JN 22007

Subject: **Review of Revised Plans**
Proposed New Residence
6950 Southeast Maker Street
Mercer Island, Washington

We have been provided with the revised plans, which include the architectural plans (Jeffrey Almeter; June 2, 2023), shoring plans (Jeffrey Almeter and Buker Engineering; June 2, 2023), civil plans (Goldsmith Land Development Services; June 2, 2023), and the structural drawings (DS Engineering; February 2, 2023).

SECTION SH1 1
SCALE: 1/4" = 1'-0"

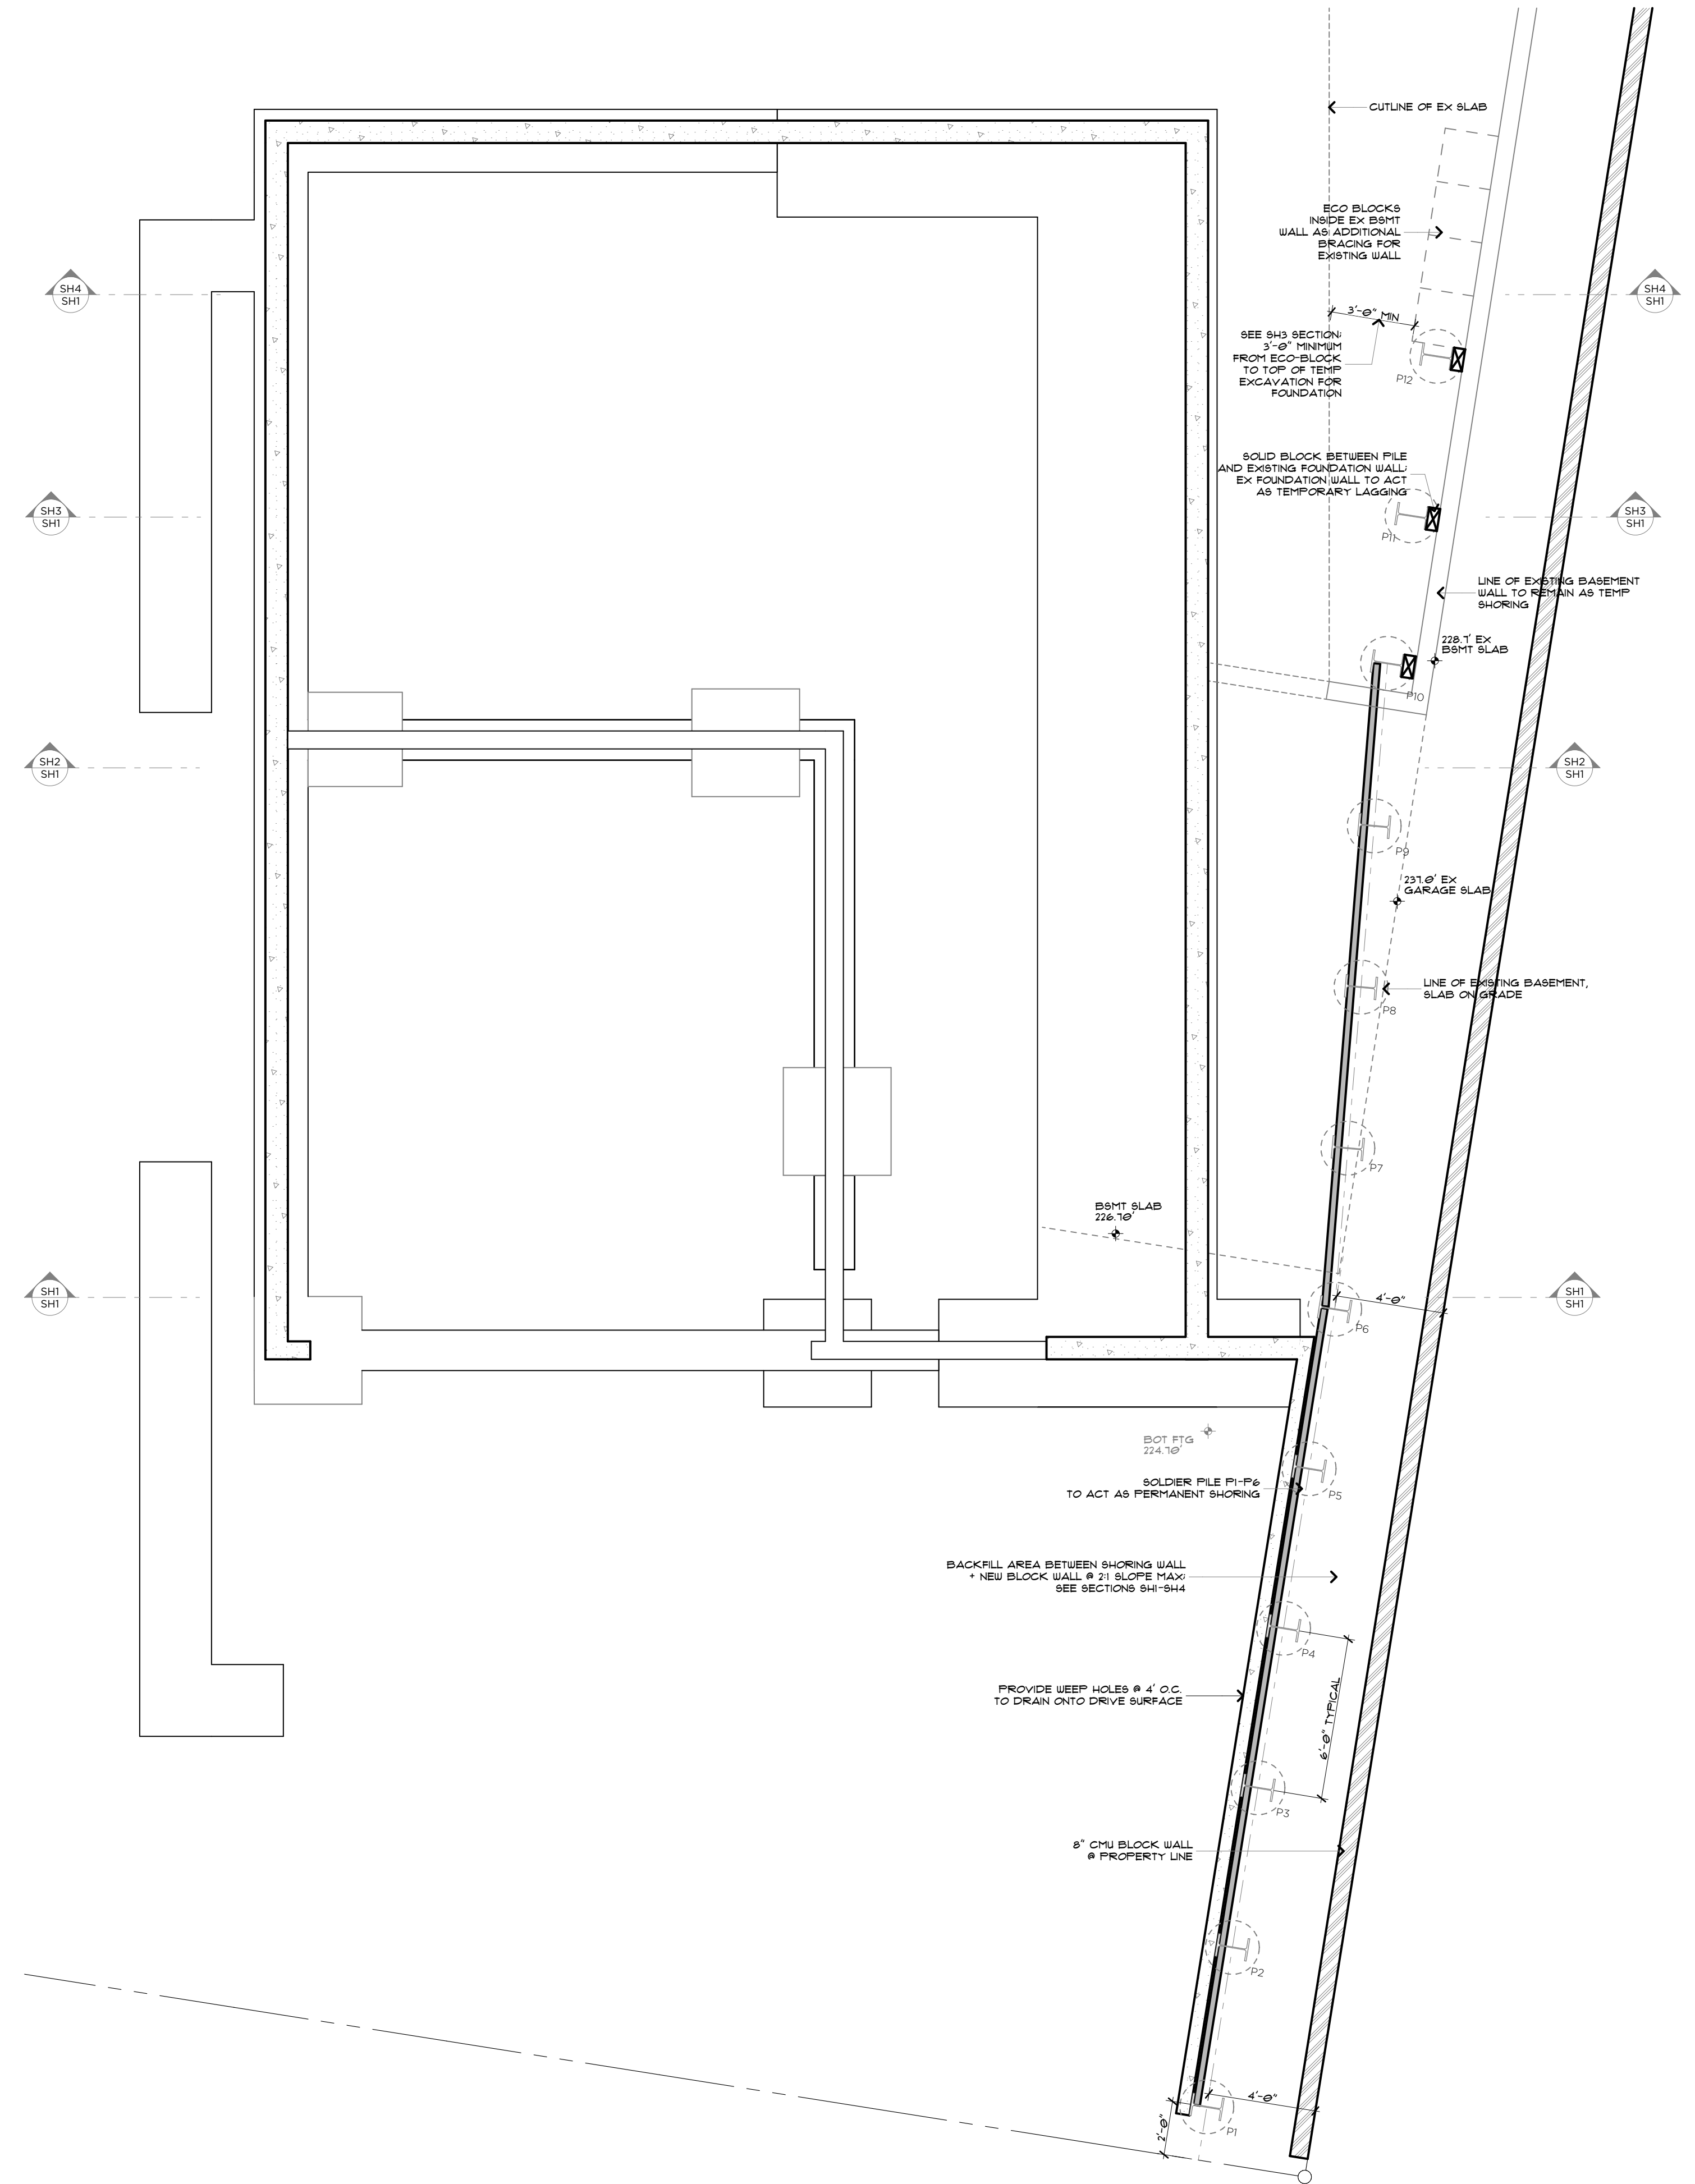
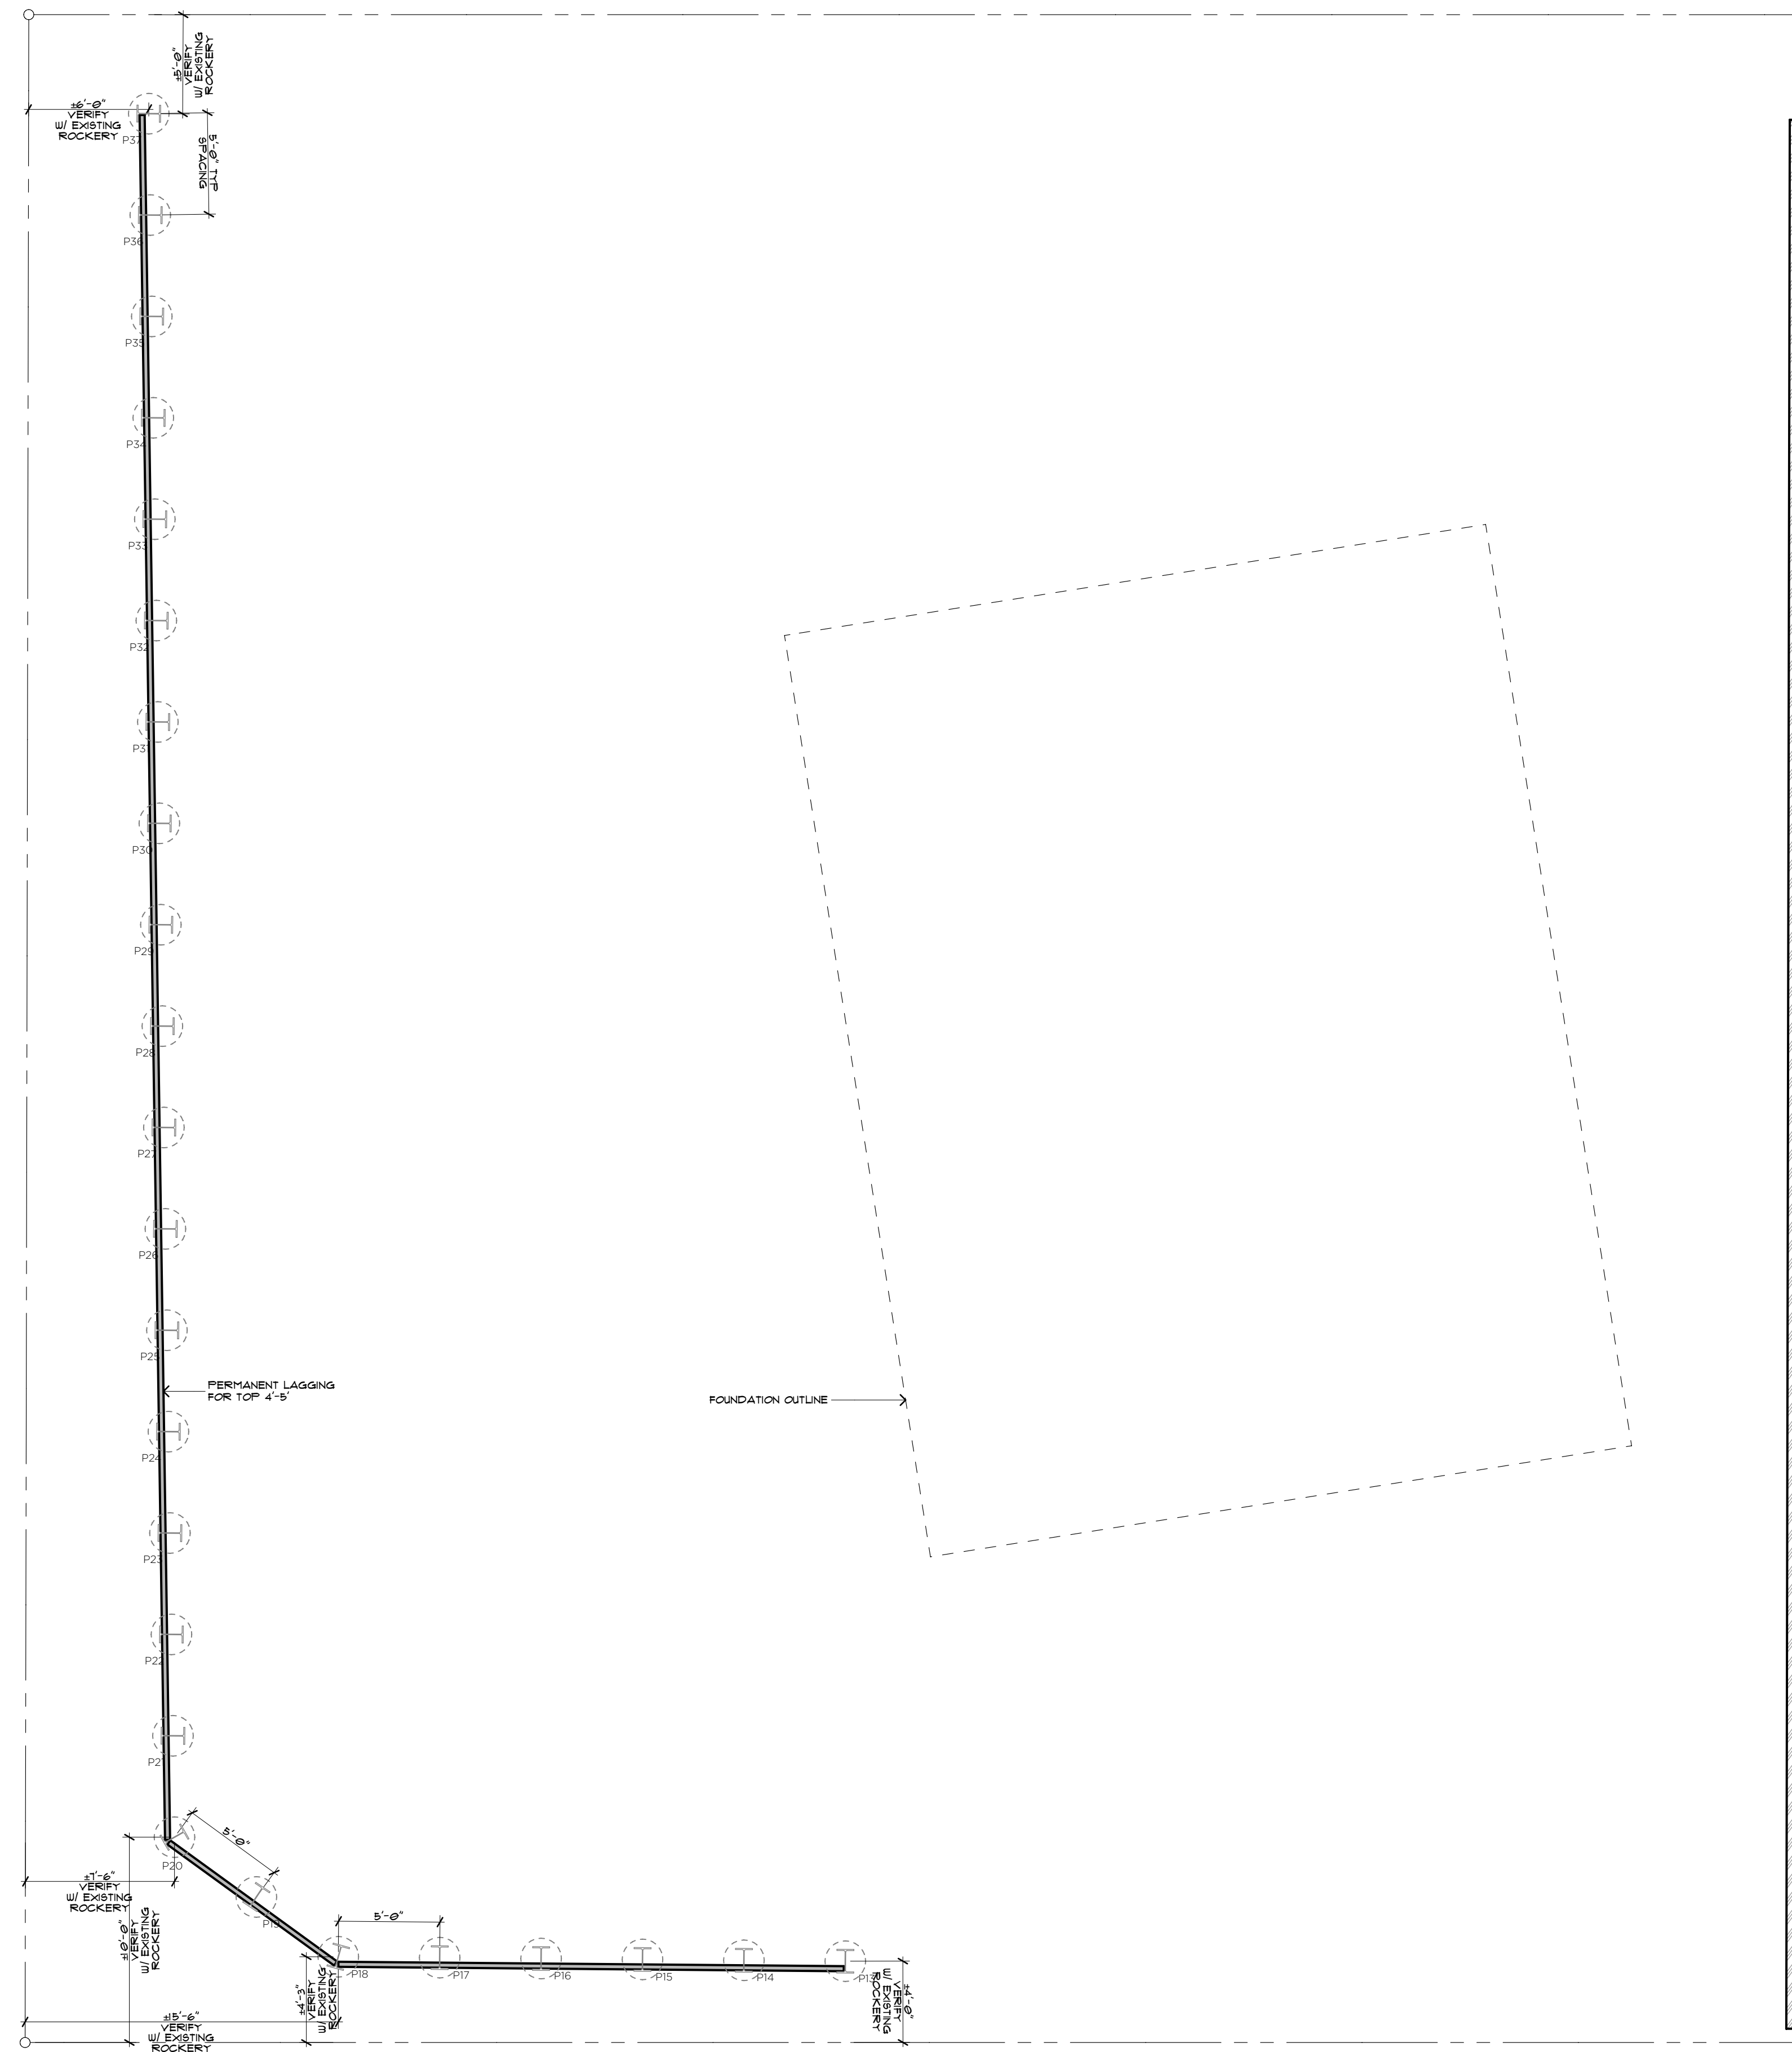
The shoring (SH) drawings correctly depict the partial removal of the existing western rockery, combined with the installation of closely-spaced soldier piles immediately behind the remaining lower portion of the rockery. The remaining lower approximately 5 feet of the rockery will no longer have to resist any lateral soil load, as this will be accomplished by the stabilization piles. This

system incorporates our recommendations to provide stability for the existing fill located on the west side of the lot.

The Site Plan and sections on SH1, as well as sheets C-2 and C-3, properly illustrate the fill berm and modular block wall to be constructed as protection against a potential failure of the eastern neighbor's modular block wall.
